# Agency Review Comments

Humphrey Platte Ave Self Storage

PPR2418

PR WATER MAIN - PLAN VIEW

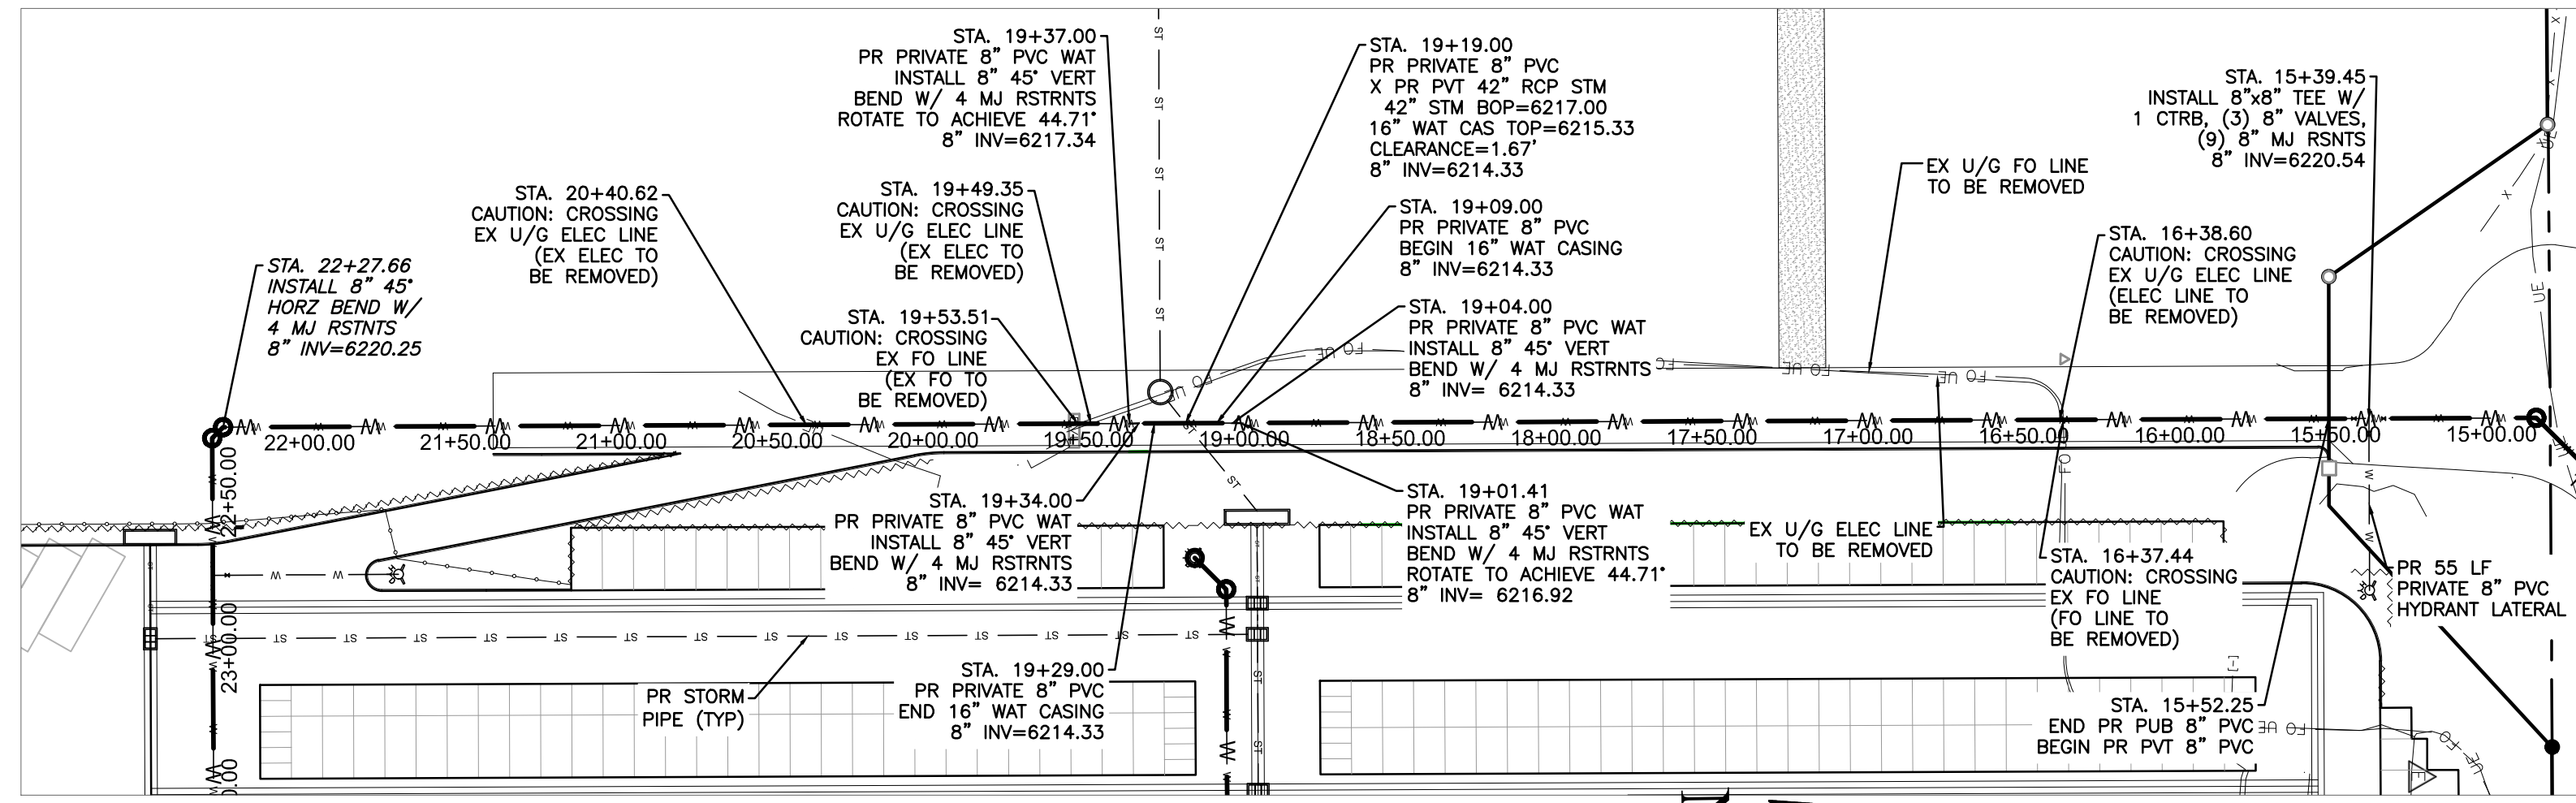
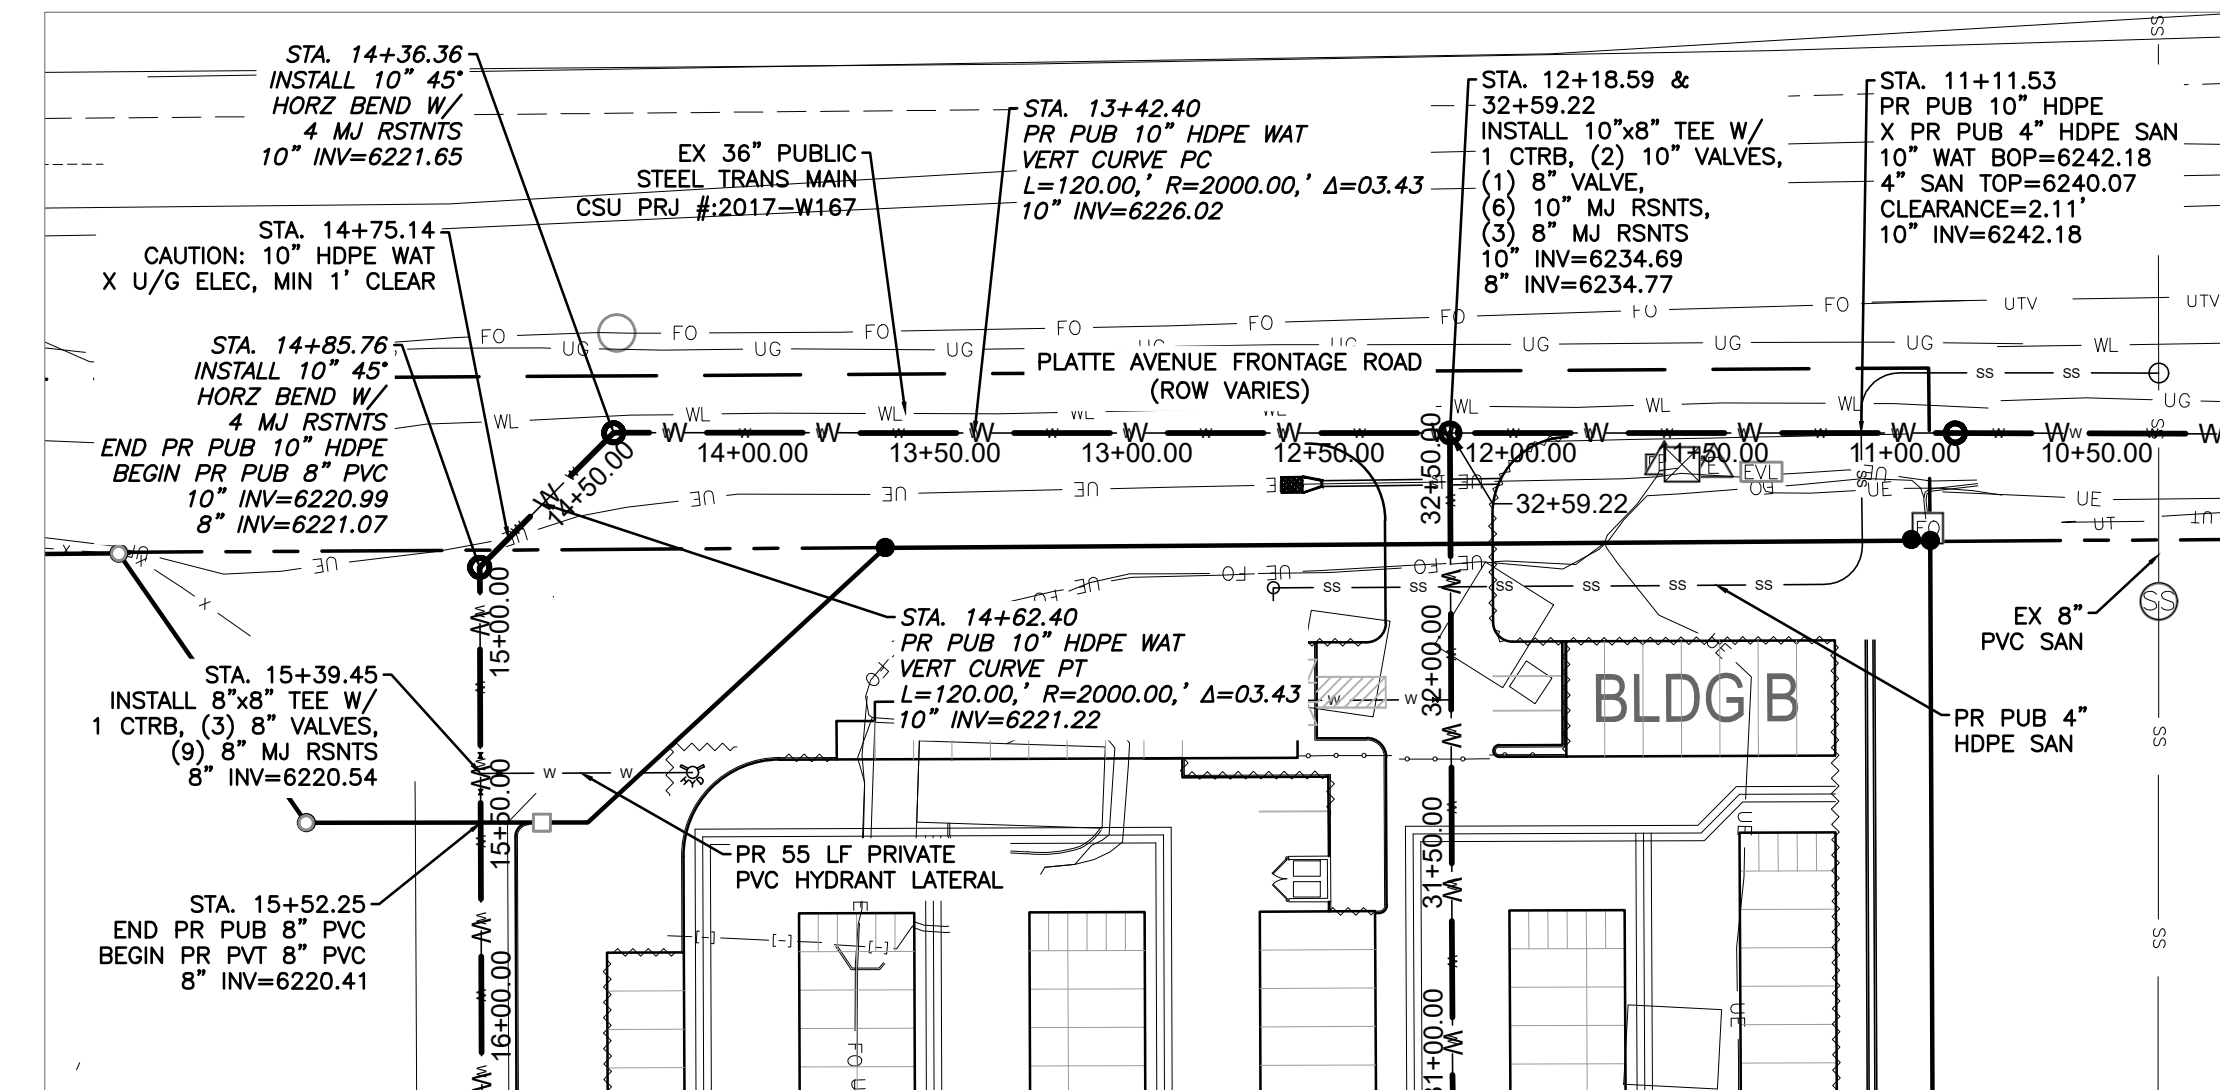
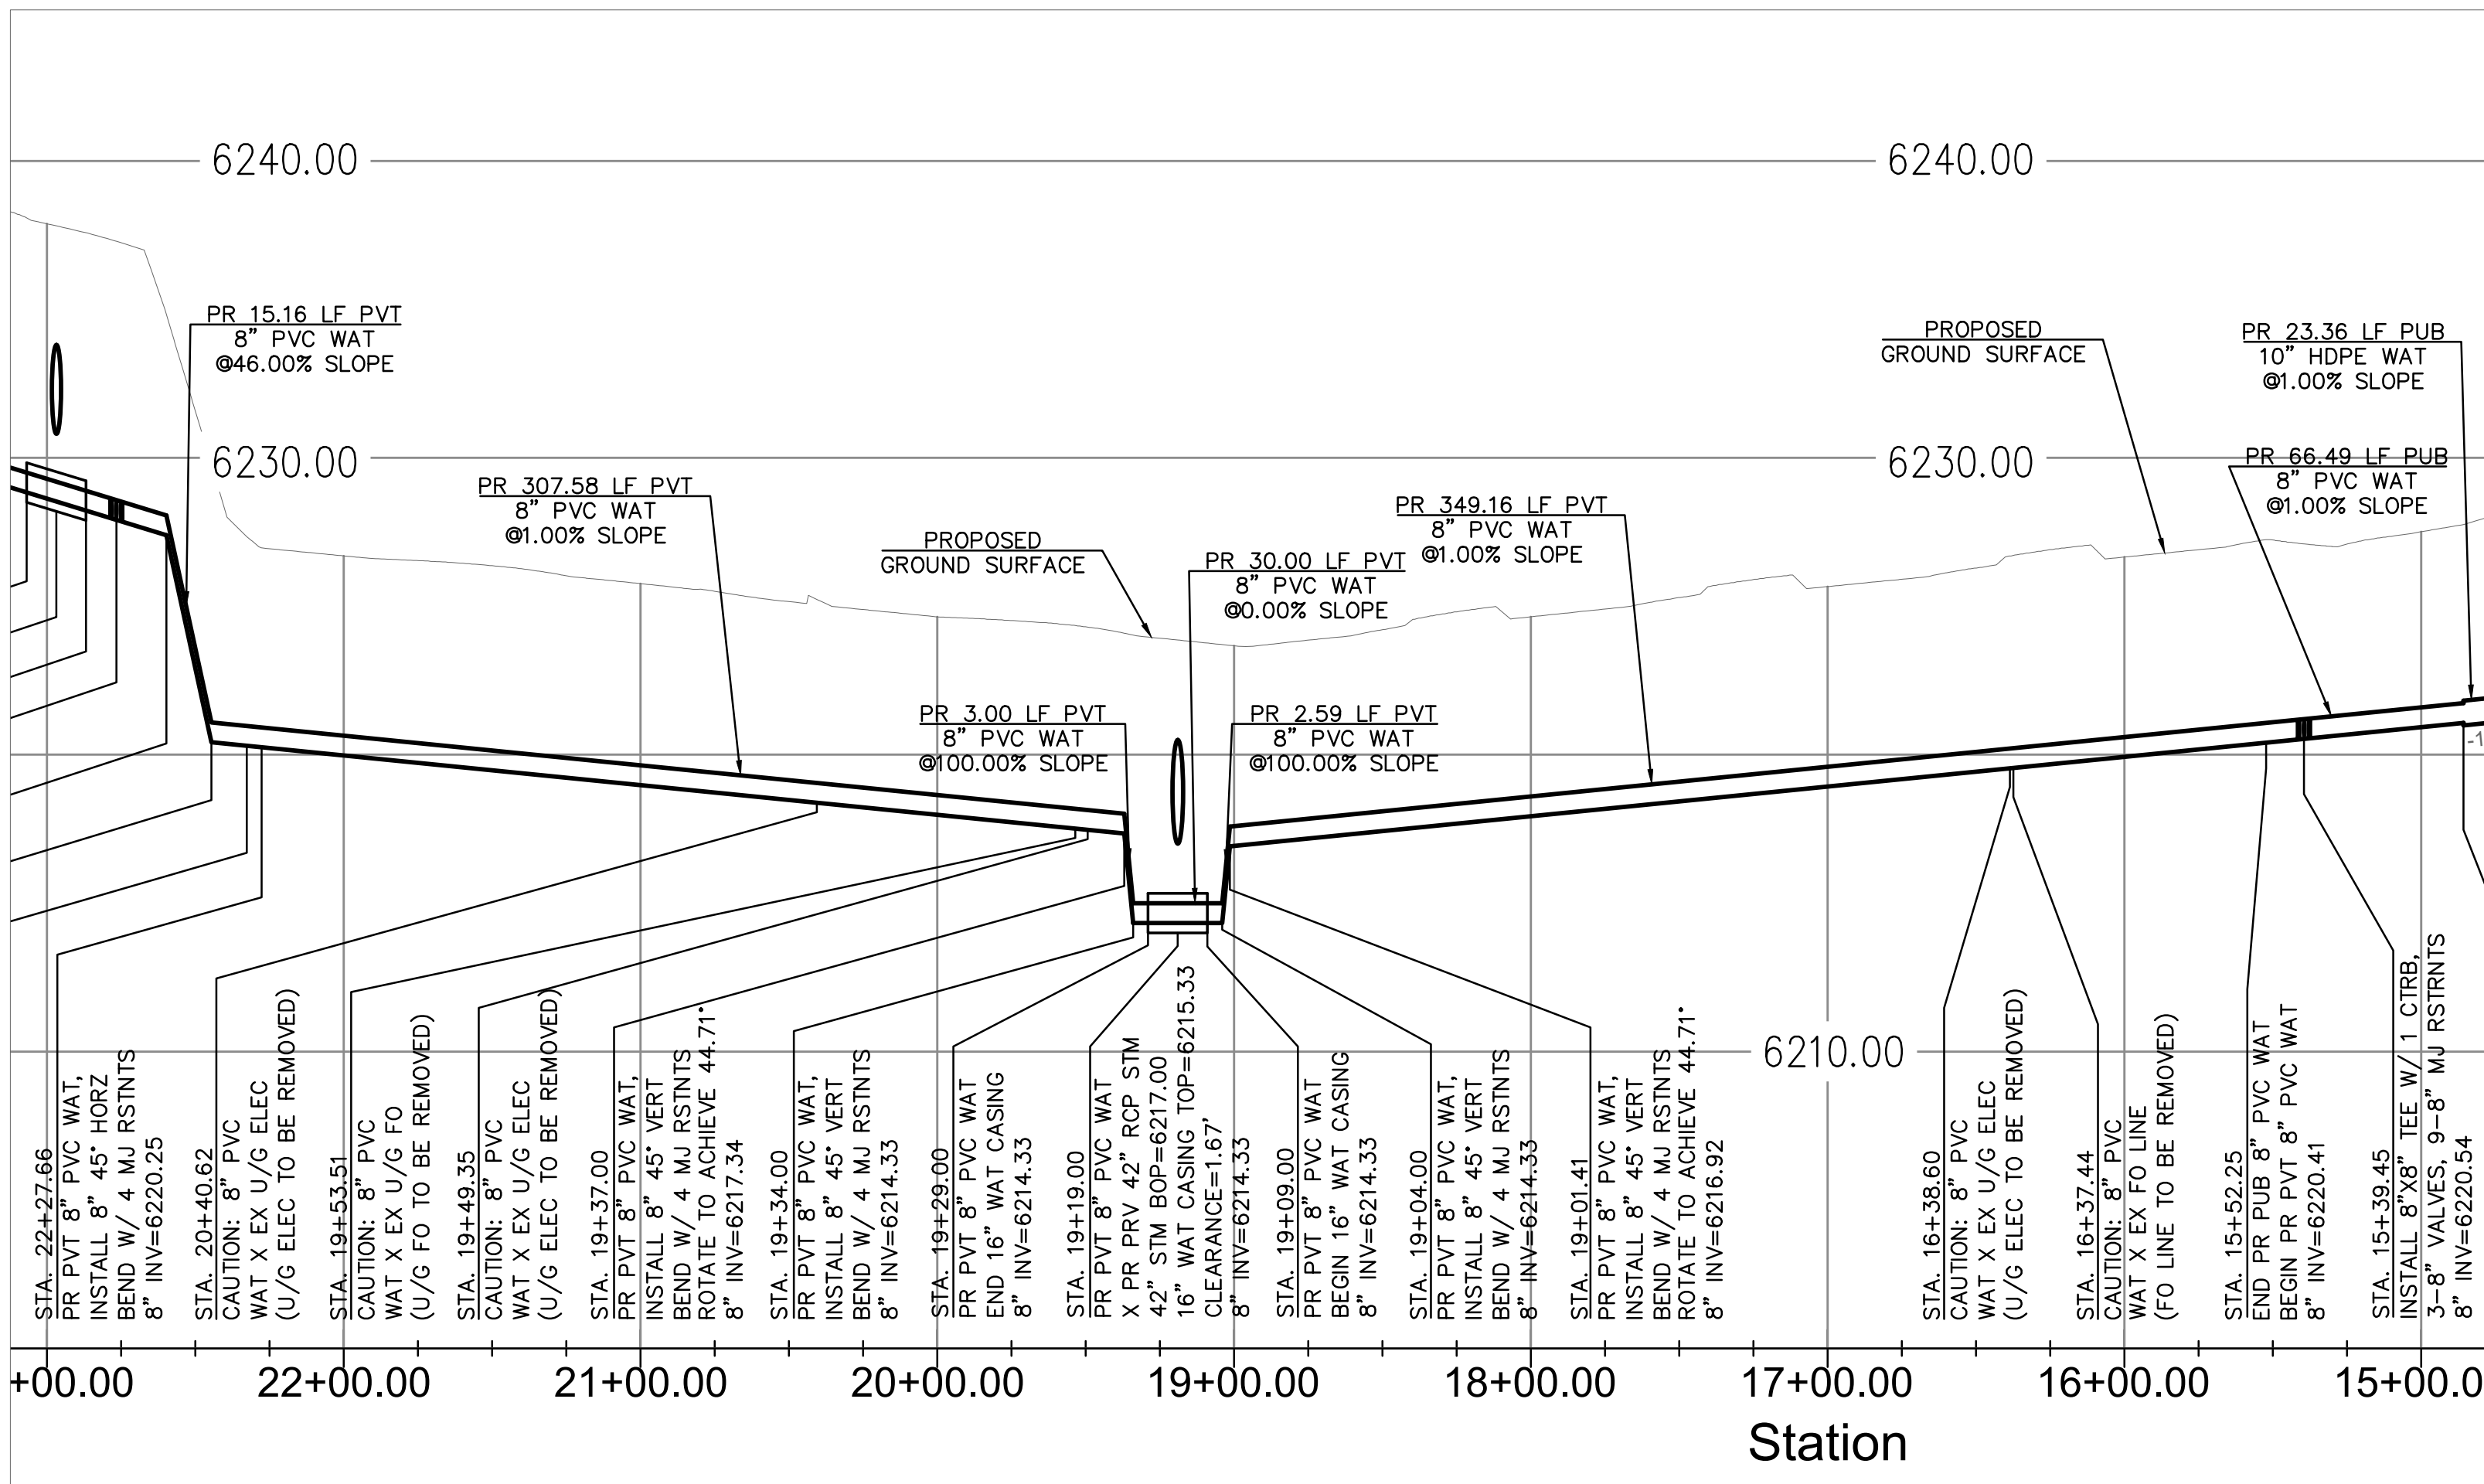
Cherokee Metro Dist		10/1/2024 3:16:56 PM
Cherokee Metro Dist	<p>All comments are in reference to the "Water &amp; Utility Service Plan"</p> <p>On page 1, cover page, under general notes and water plan notes it should state that methods and materials shall meet Cherokee Metropolitan District's standards. <b>Added.</b></p> <p>On page 2, it should state that manholes to Cherokee standard are a minimum of 5' Internal diameter. <b>Added.</b></p> <p>Additionally, on page 2, a sanitary tie in detail to the existing force main needs to be included within the utility plan (it can be on a sheet at end of utility plan). <b>There is no existing force main. The force main is proposed and nothing is tying into it.</b></p> <p>On page 3, include within the open area a utility crossing table with all proposed lines crossing existing; include both water and sanitary lines for the crossing table and identify on plan. I have also attached marked up sheet of page 3 and page 5, "water plan overview" and "water main plan &amp; profile", from our District's locator. Add the Blue and Red marked notes to the respective sheets. <b>Crossing table added.</b></p> <p>Additionally, throughout the "water &amp; utility service plan", starting on page 2 and going to page 7. All HDPE pipe that is on public road needs to be changed to PVC (this is because Cherokee Metro does not have the equipment to do HDPE line fixes). Lines that are in Private roads can stay as is. <b>Pipe has been changed from HDPE to PVC.</b></p>	10/1/2024 3:14:02 PM
